National Infrastructure Planning  
Temple Quay House  
2 The Square  
Bristol, BS1 6PN

Our Ref: EN010127

### **Application by Mallard Pass Solar Farm Limited for an Order Granting Development Consent for the Mallard Pass Solar Project**

#### **Advice following issue of decision to accept the application for examination**

### Access and Rights of Way Plans

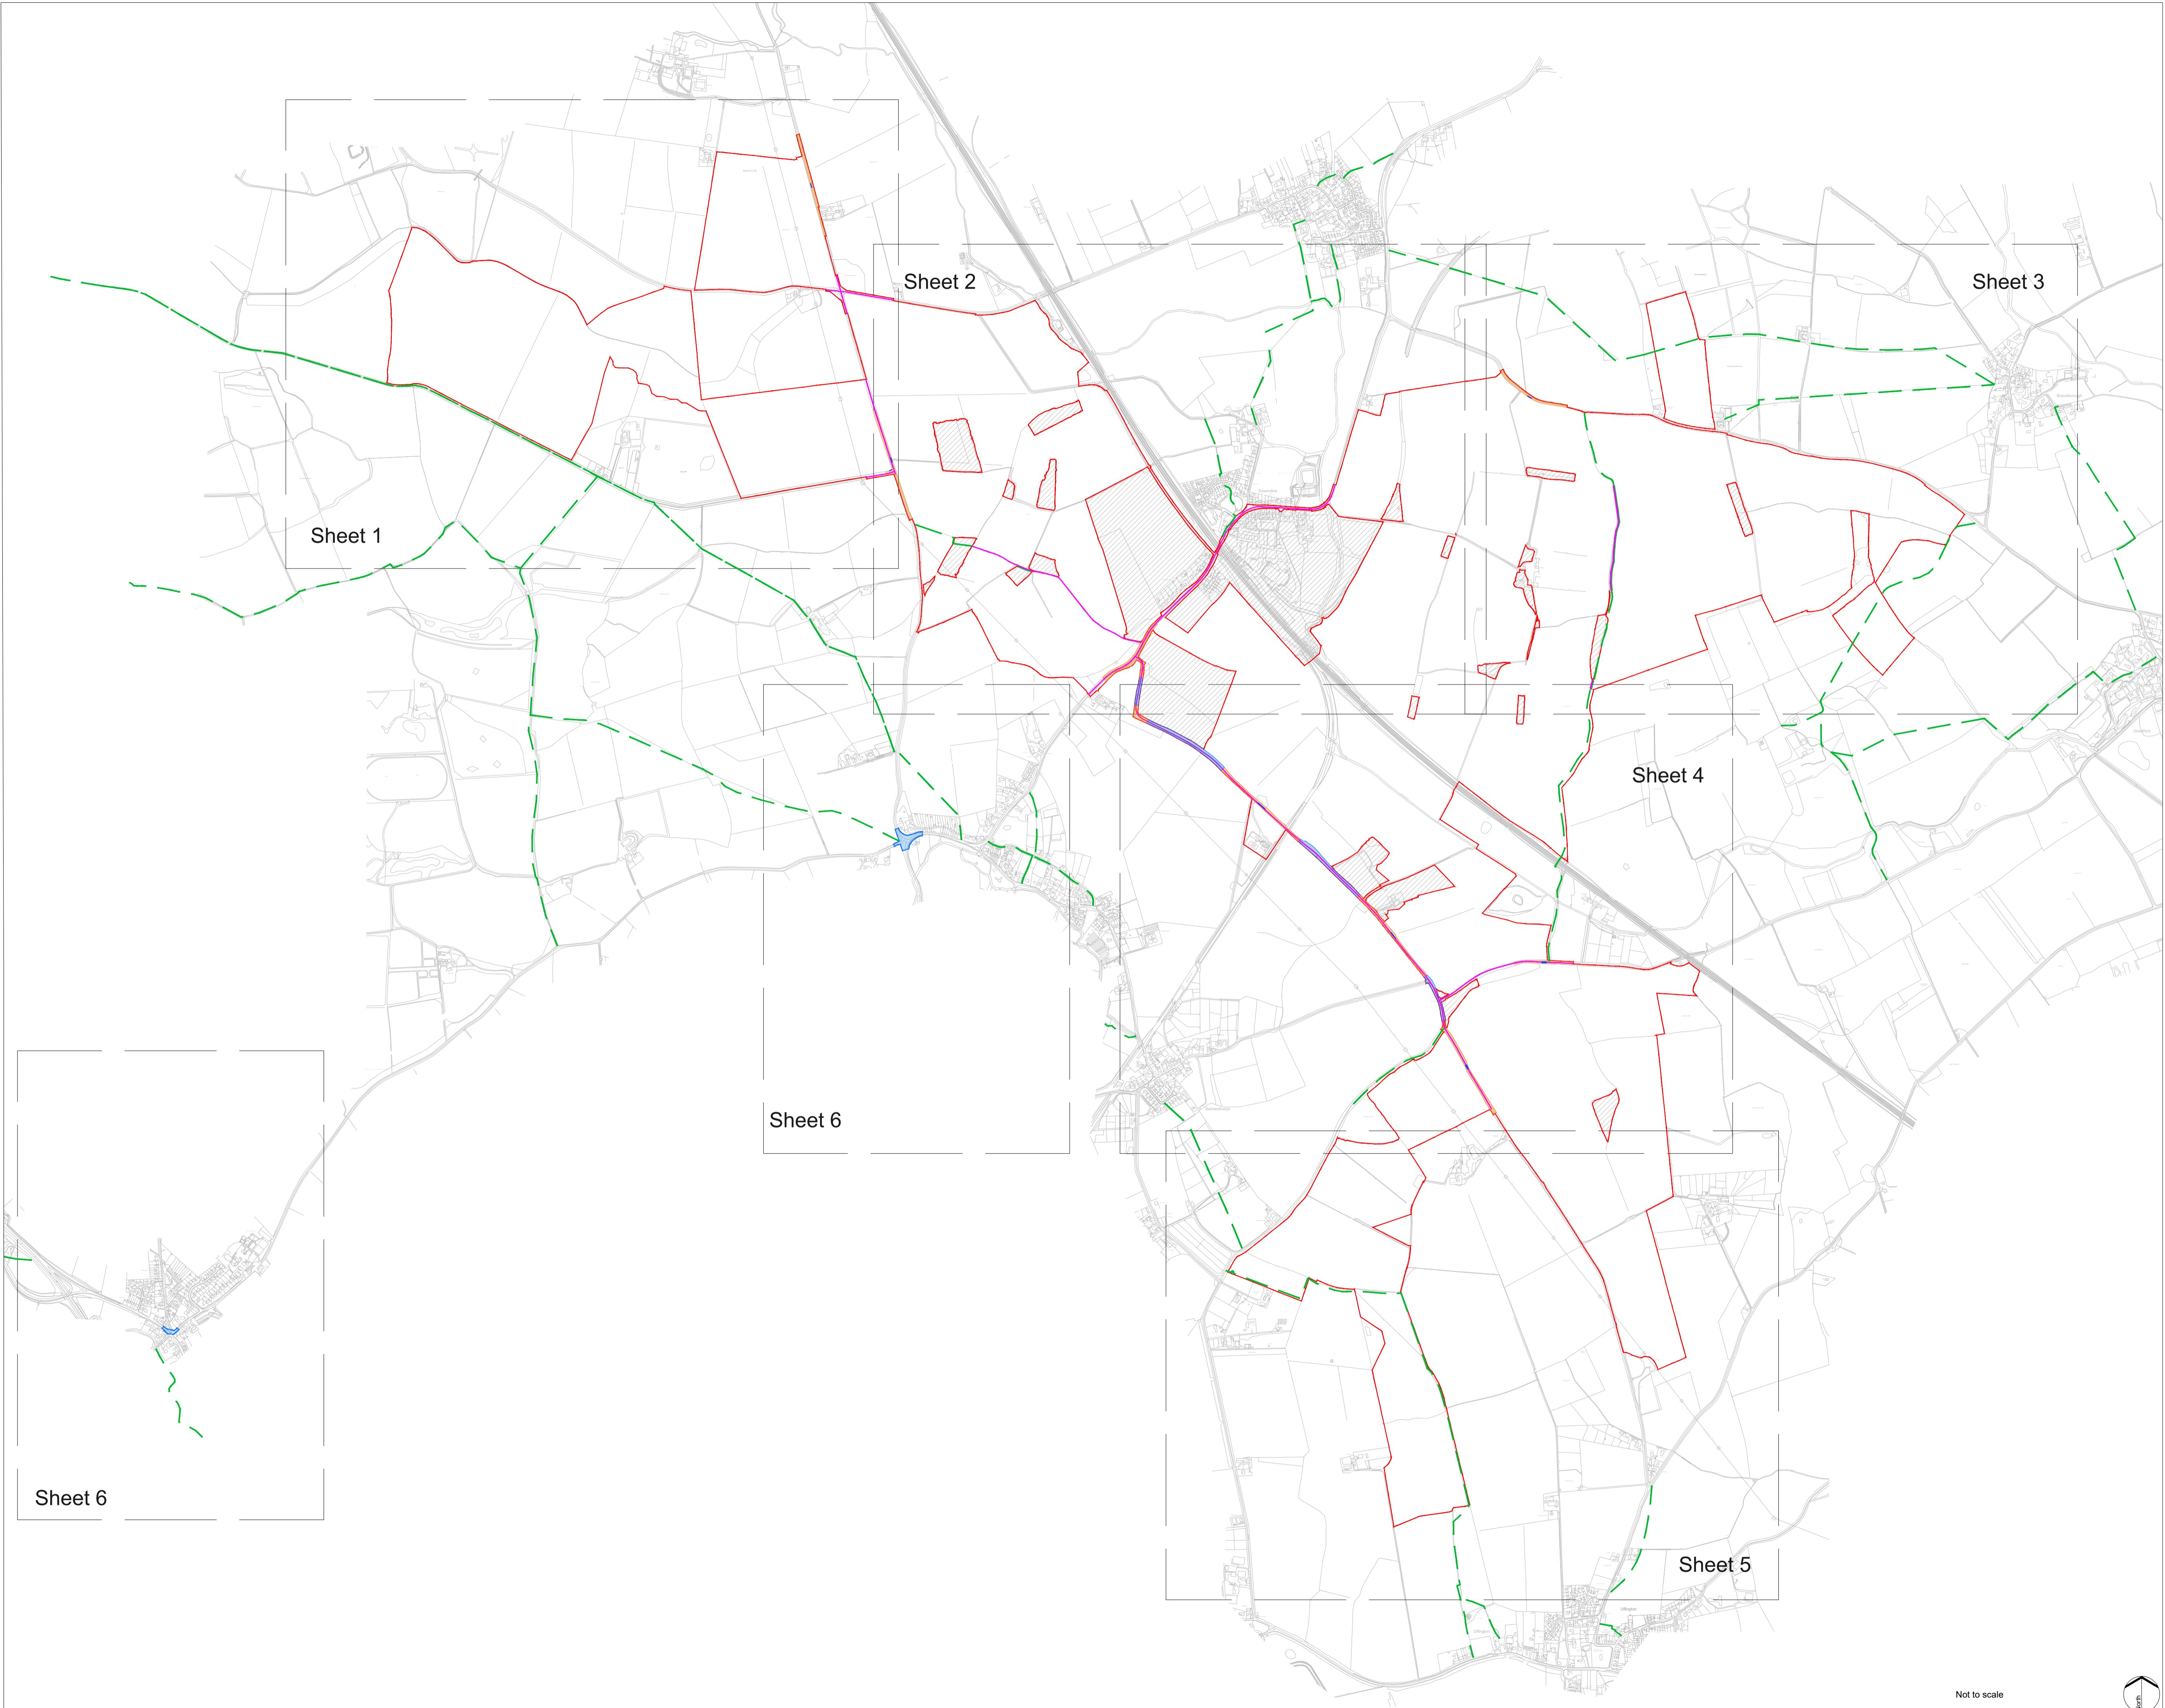
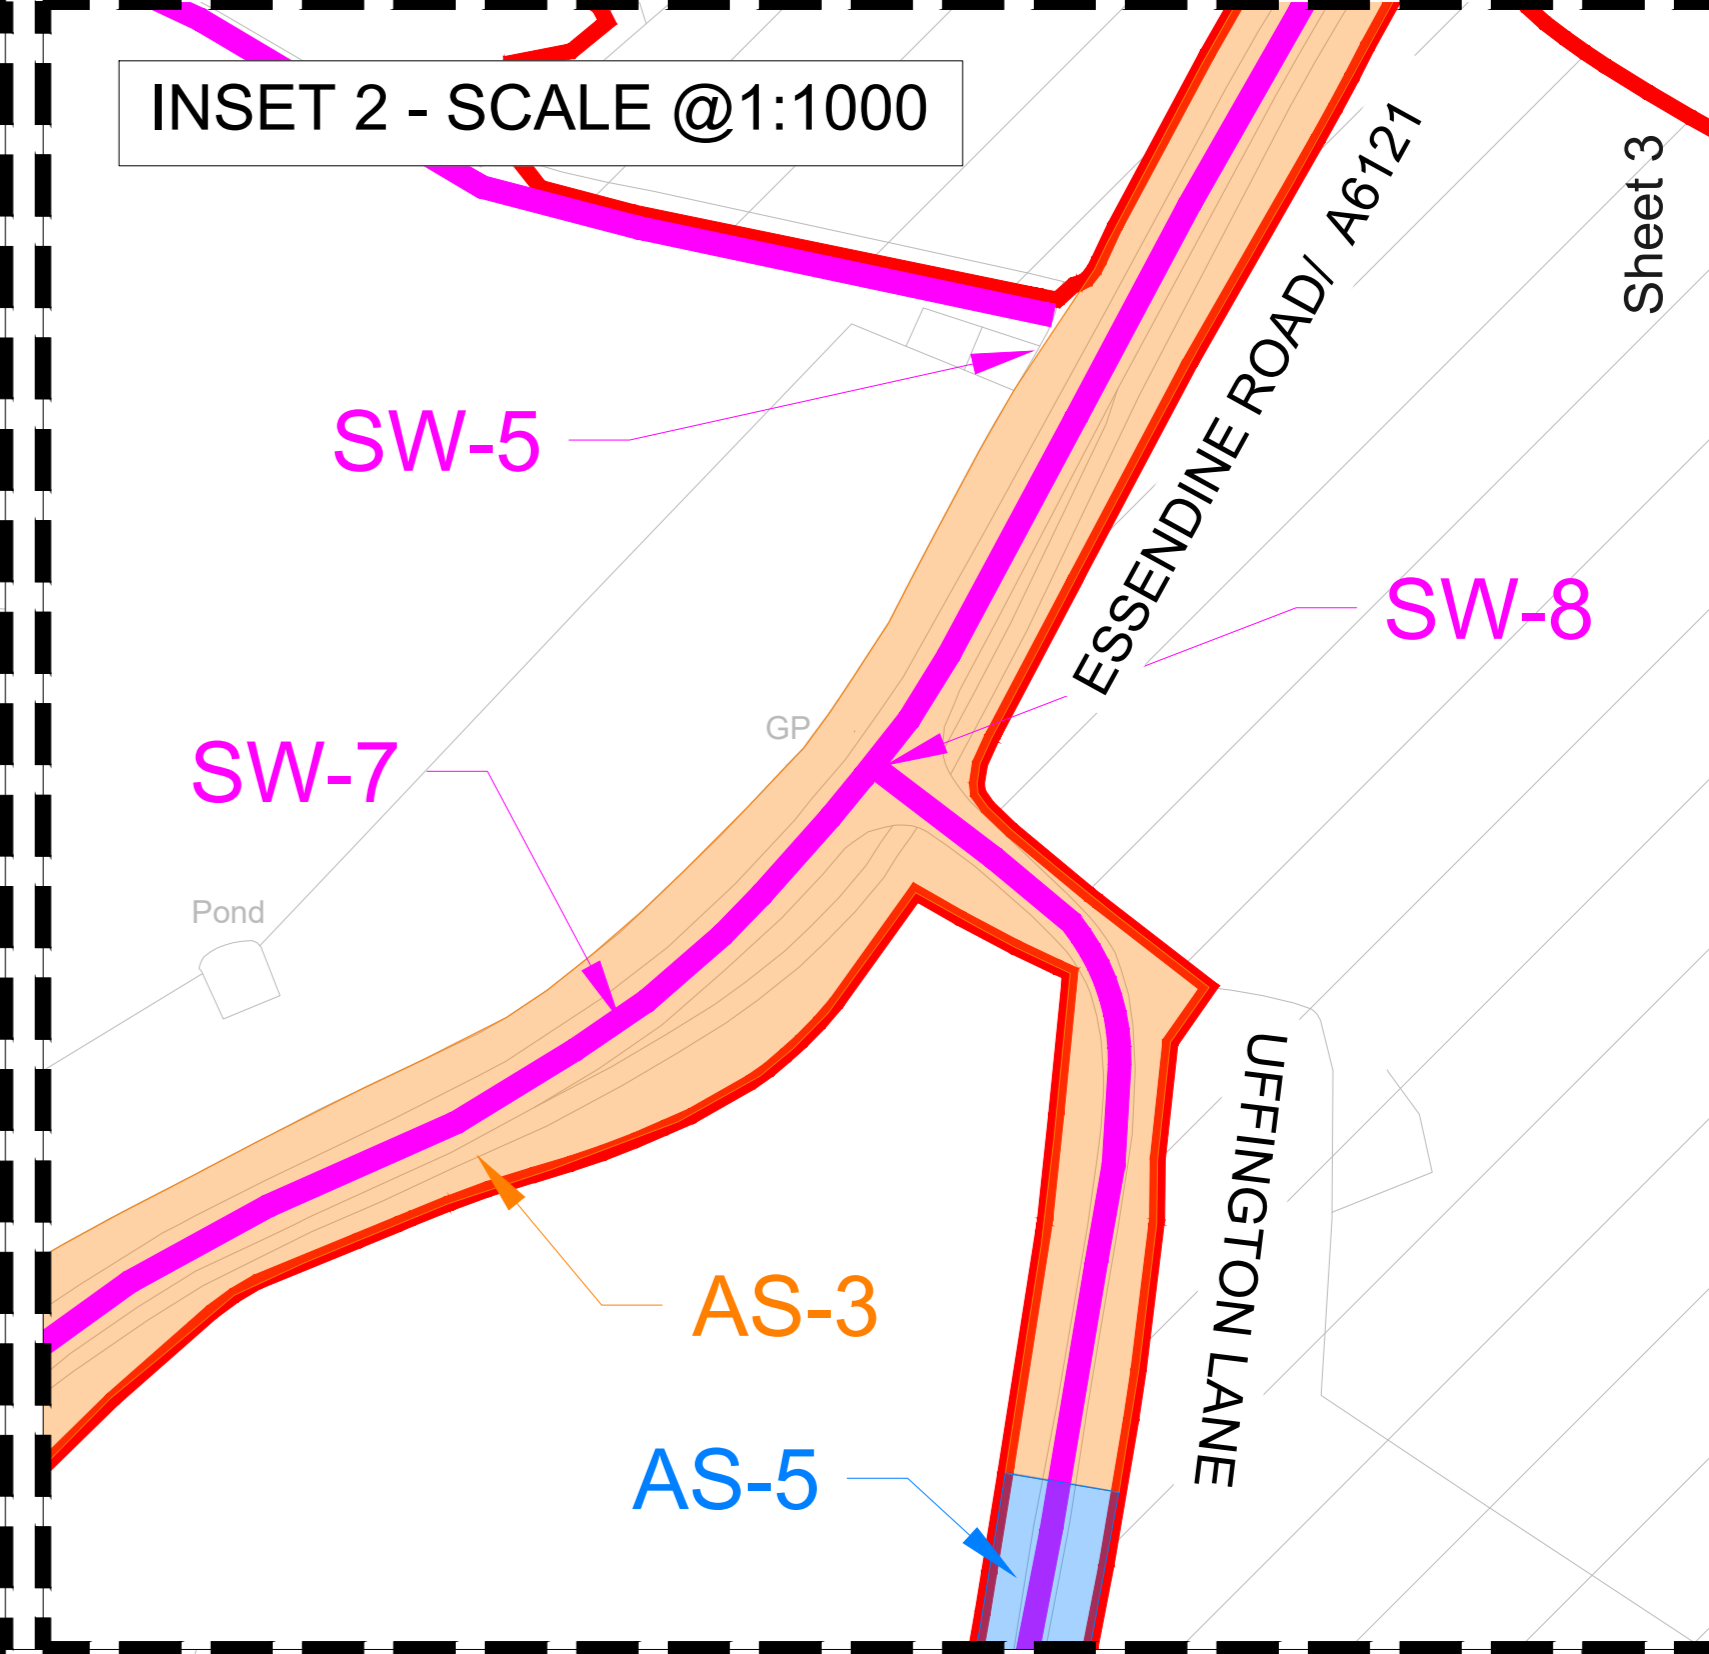
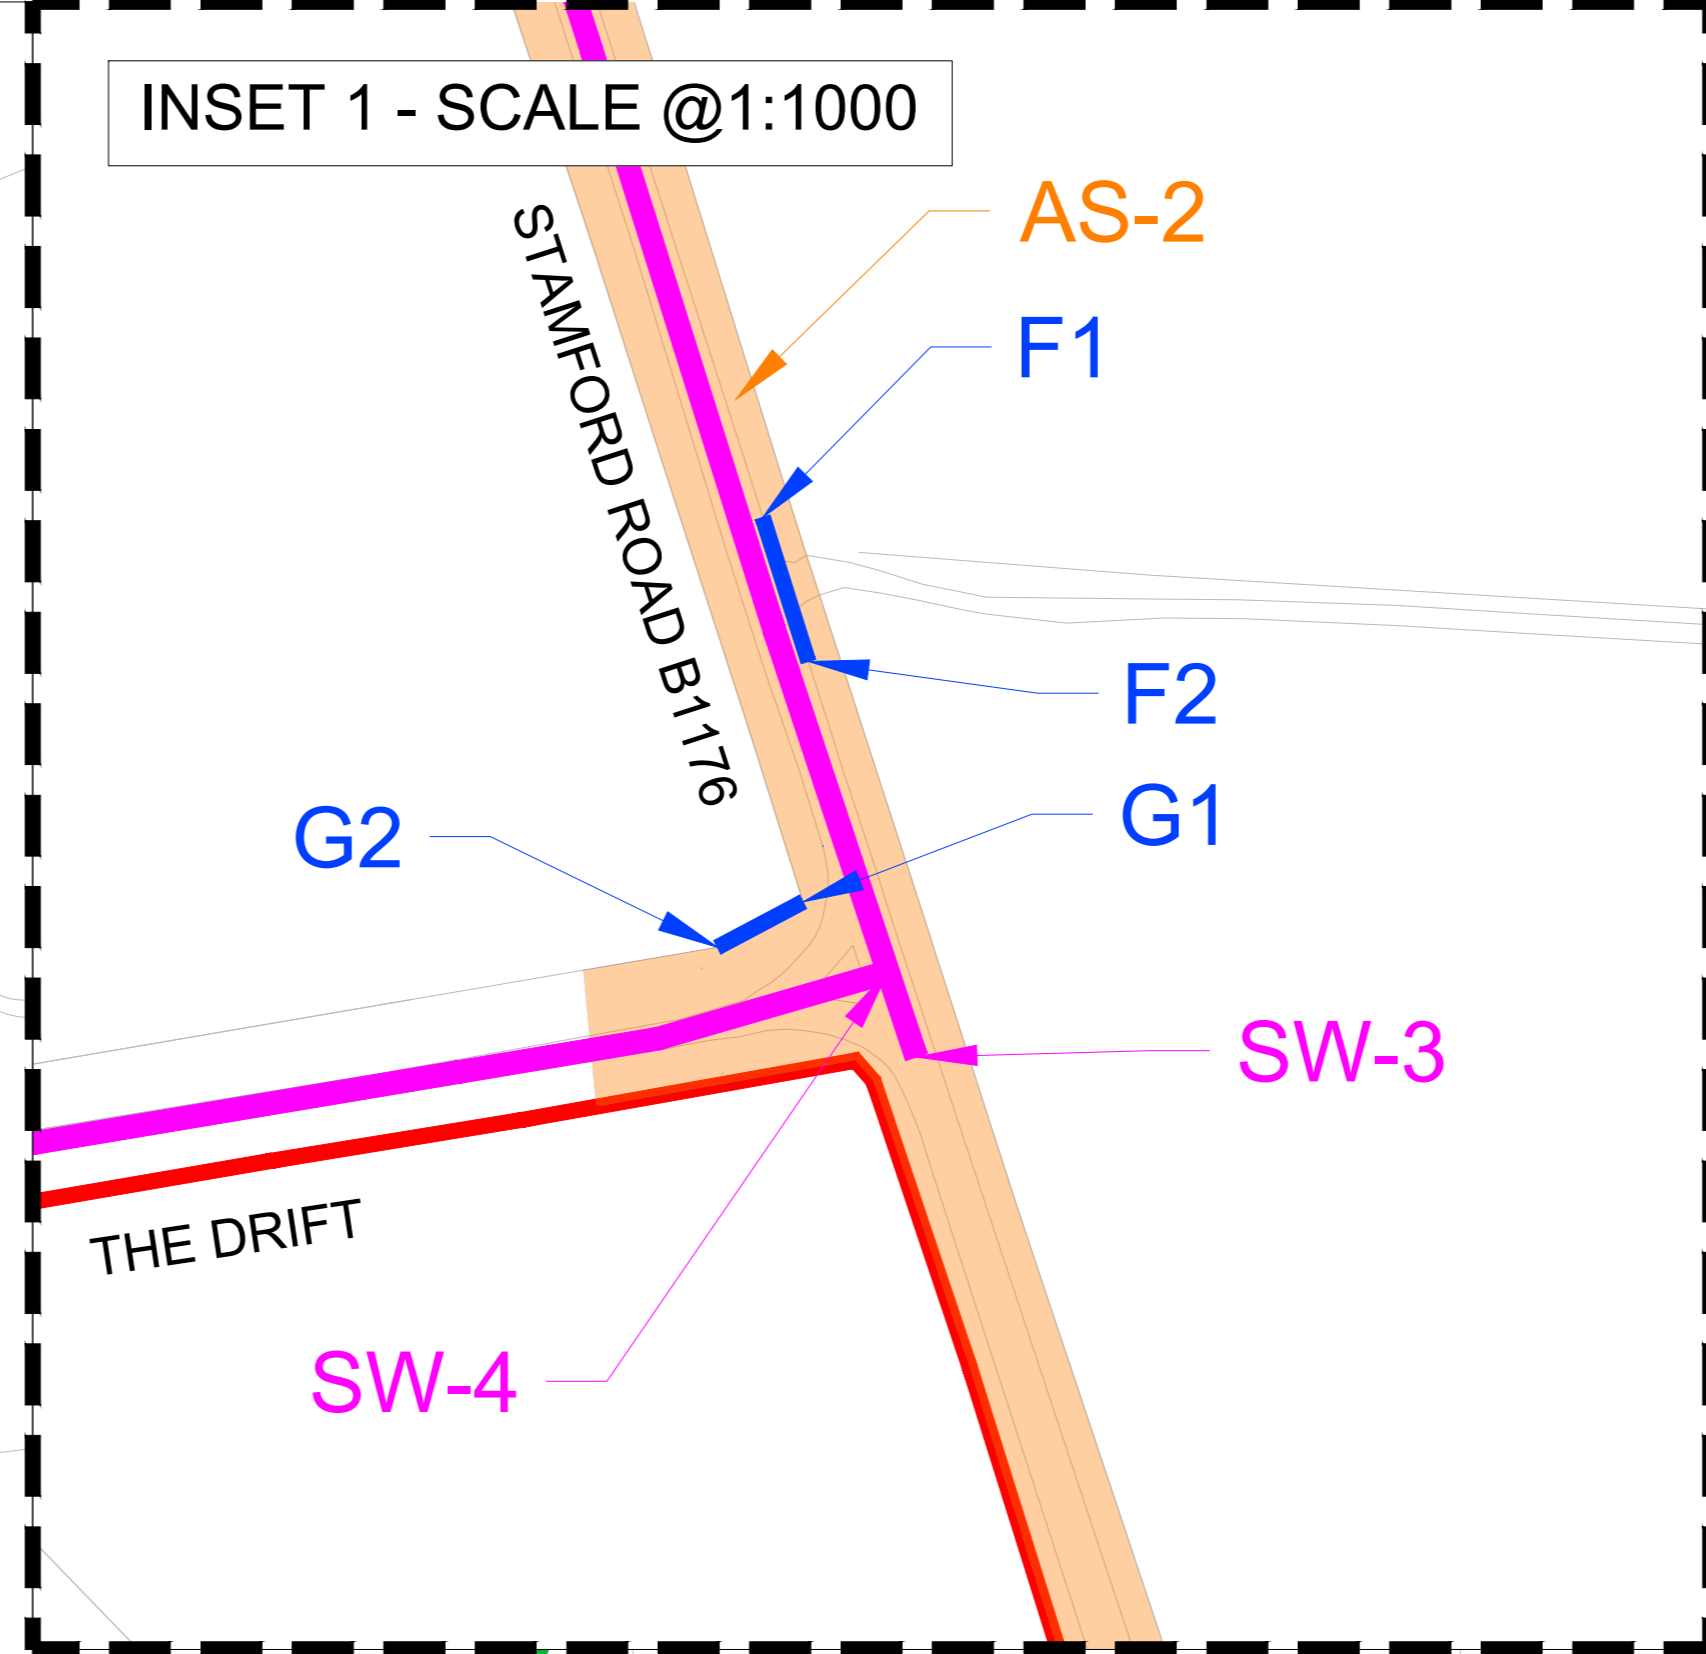
For clarity and to help understanding, existing public footpaths (public rights of way) should be marked and the plans more clearly notated to reflect the proposals, including differentiating works to footpaths and roads.
